Application No: BN/142/21/PL
Site Address: 1 Como Barnham Road Eastergate PO20 3RT
Description of works: Erection of a new two-storey building to contain 2 No 2 bedroom flats with associated parking, bin and bike stores and landscaping. This site is in CIL Zone 2 and is CIL Liable as new flats.

Thank you for your internet representation made on 9th December 2021 which has been recorded as an objection with the comments as follows:

Elevations (1:100)

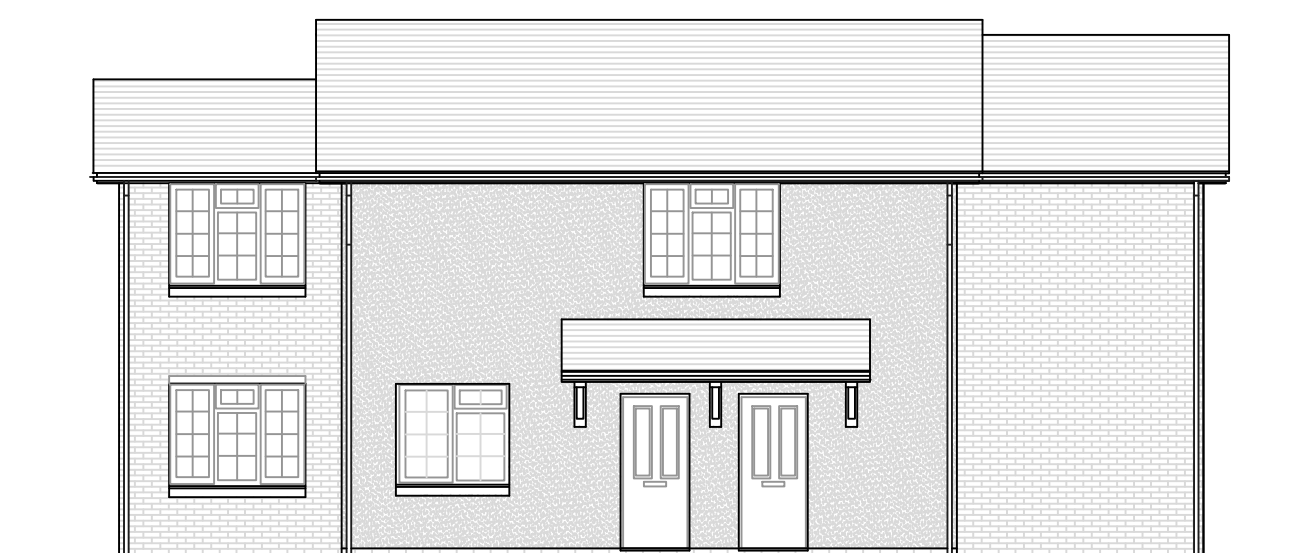
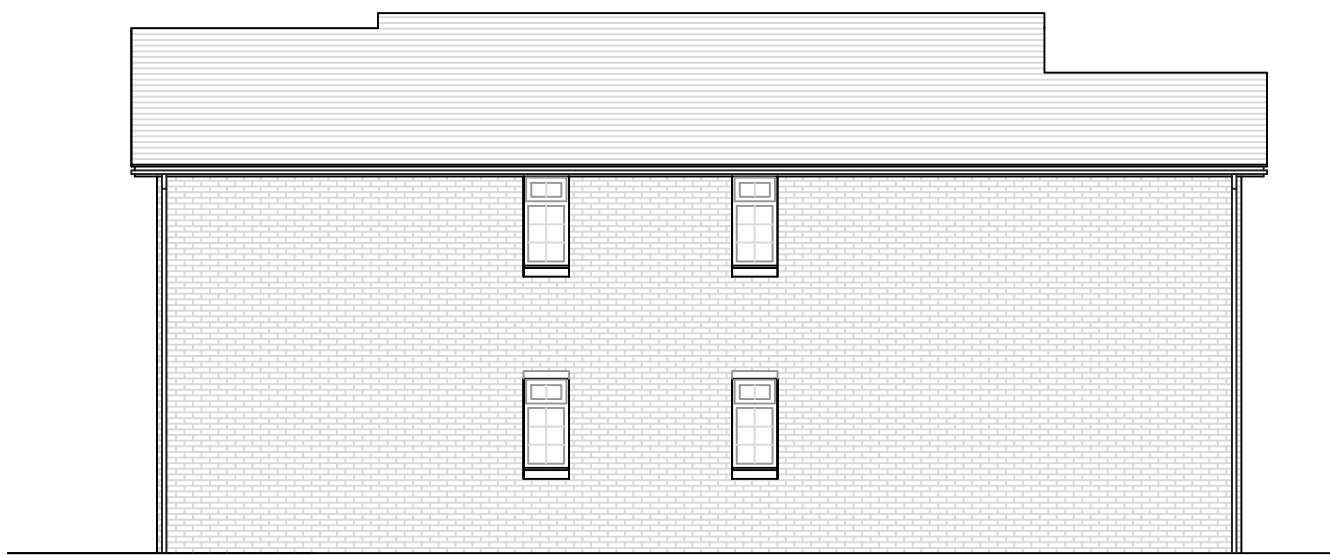
- 1) The proposed two-storey building would be out of keeping with the surrounding area as it is an in-fill development that breaks the property line and directly overlooks neighbouring back gardens, potentially blocking sunlight from the immediate neighbour for part of the day; it will adversely impact the street scene and is out of keeping;
